June 26, 2008

RE: 340 Allen Avenue – 344-E-036 – B-2 Zone – Site Plan Application #2007-0189

Marge Schmuckal
Zoning Administrator

38.5'
YARD

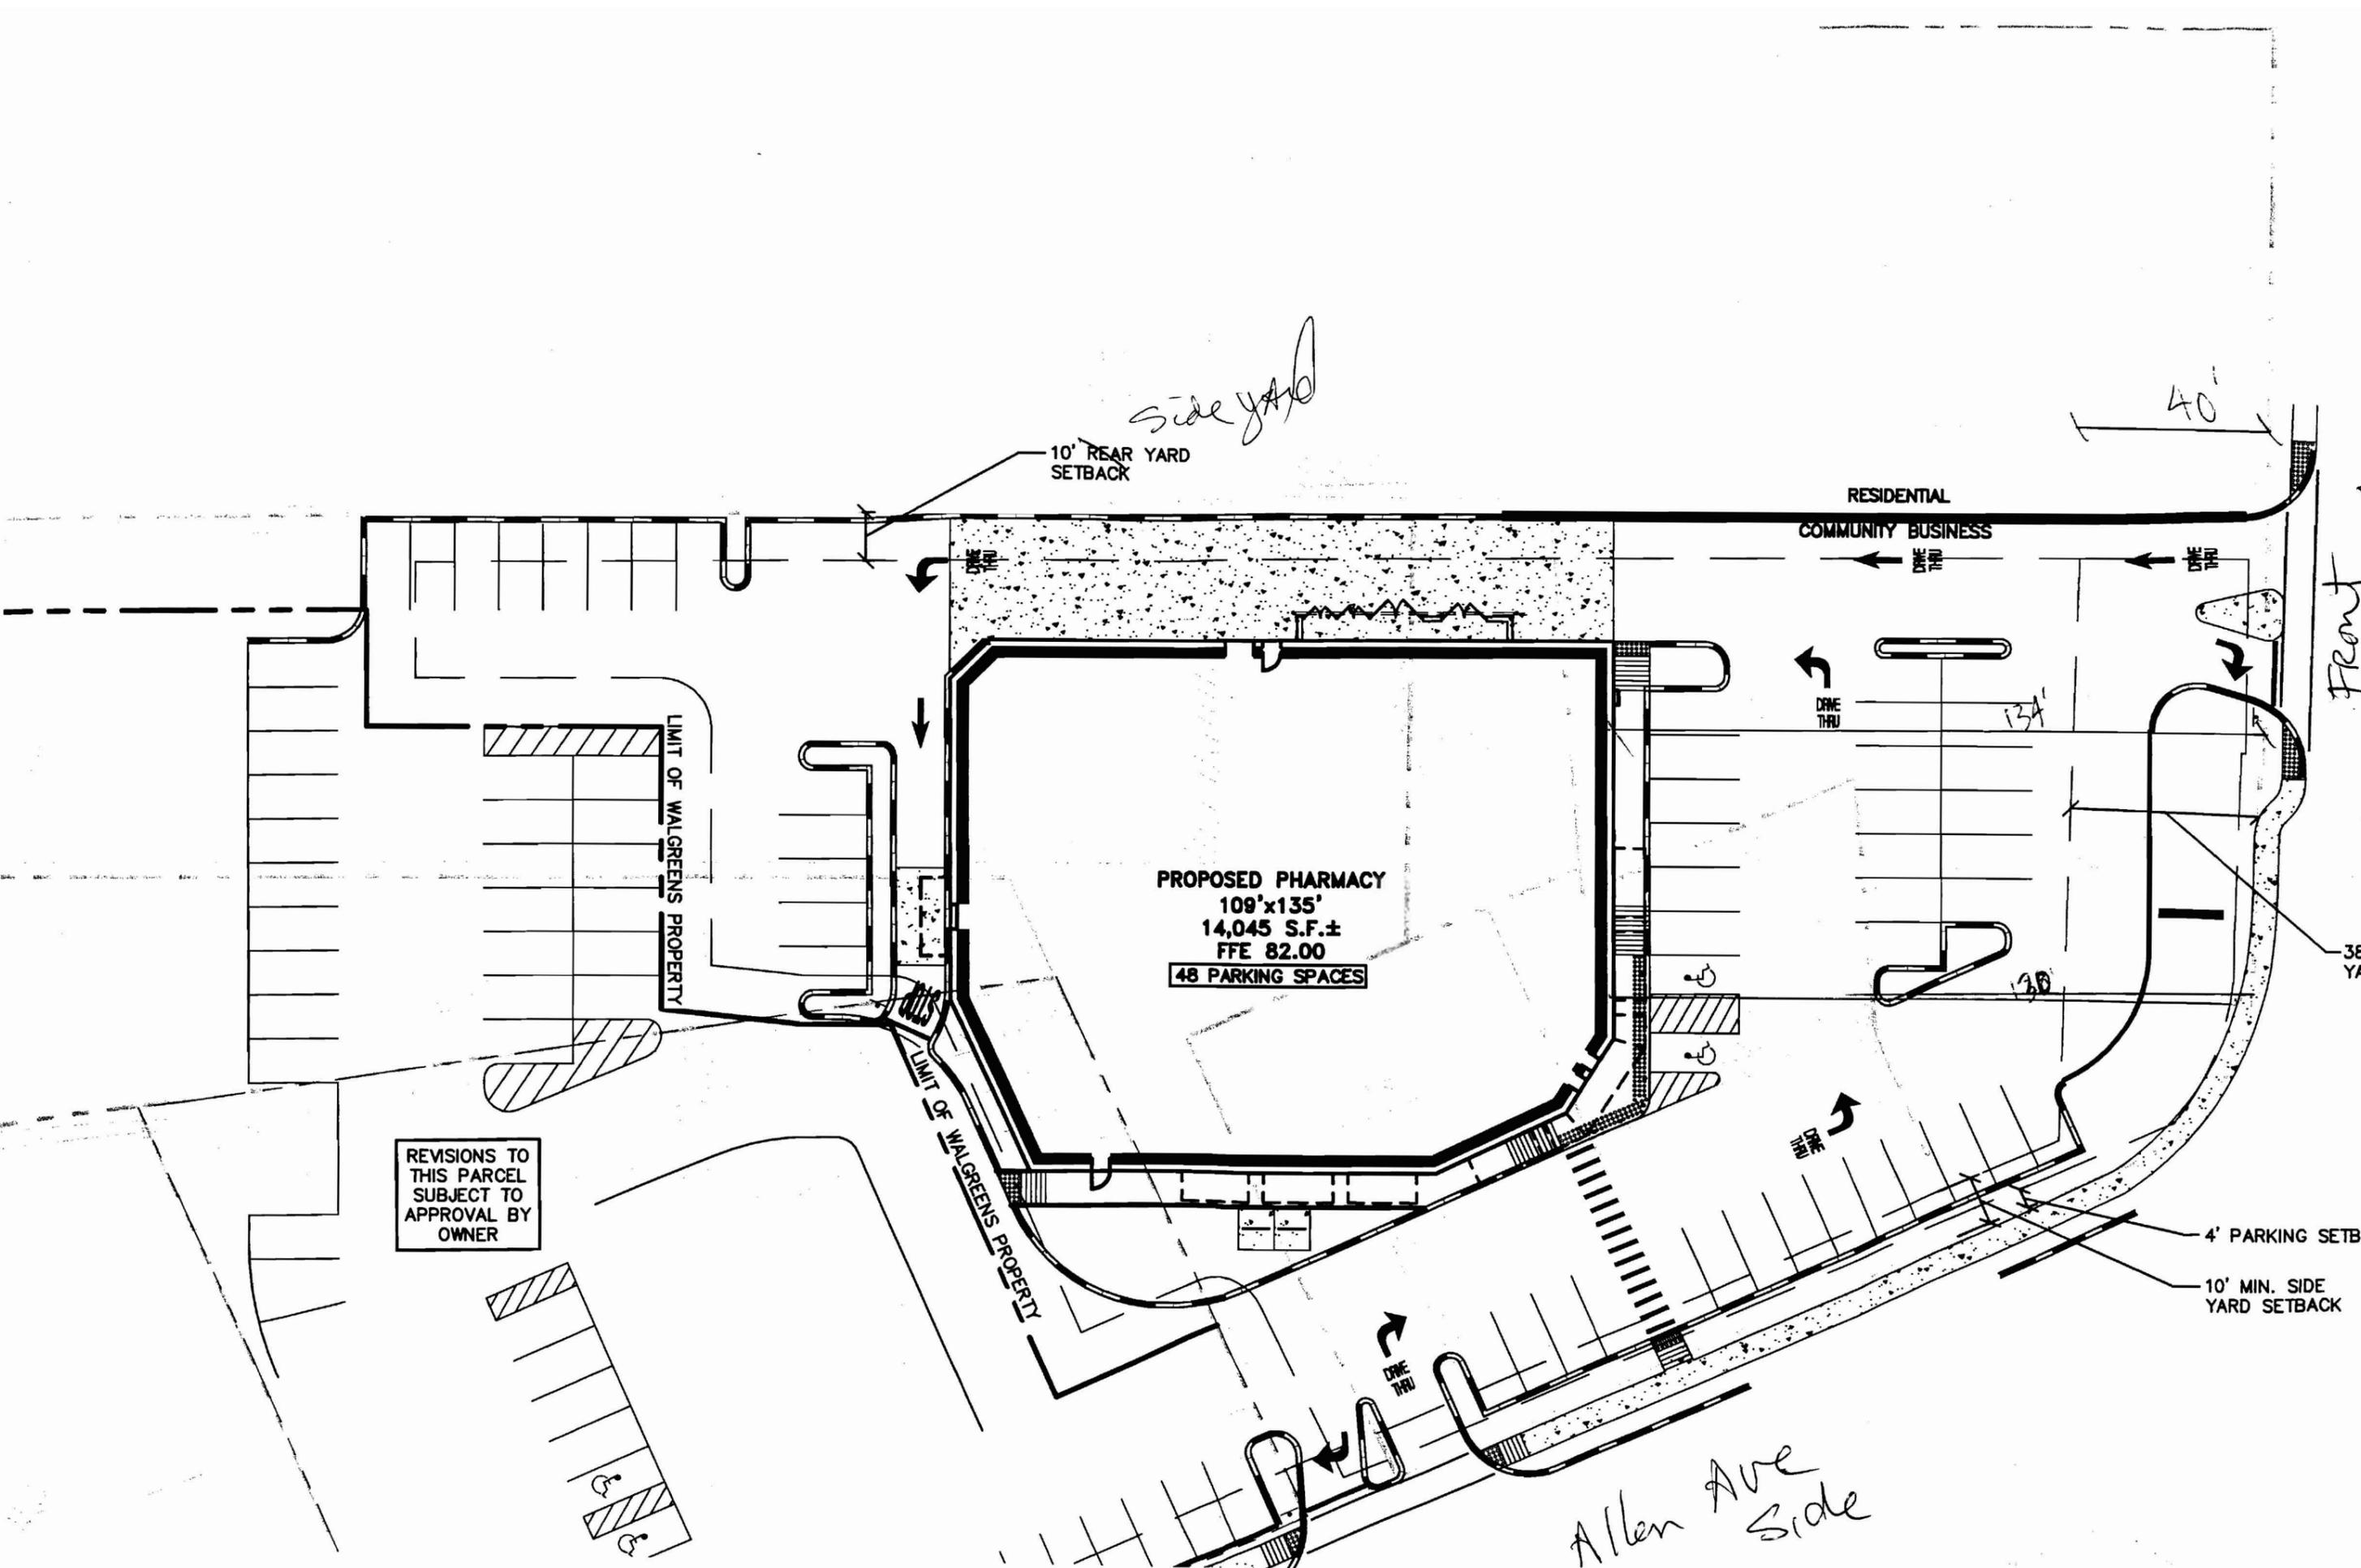
The submitted plans show a front yard setback of approximately 134 feet from the front property line off Washington Avenue back to the front of the building. These same plans are showing the average setback of buildings on adjacent parcels as 38.5 feet. My interpretation of the minimum front yard setback clearly shows the new building is setback further than what is allowed under the ordinance. The new building should be setback no further than the 38.5 feet from the front property line.
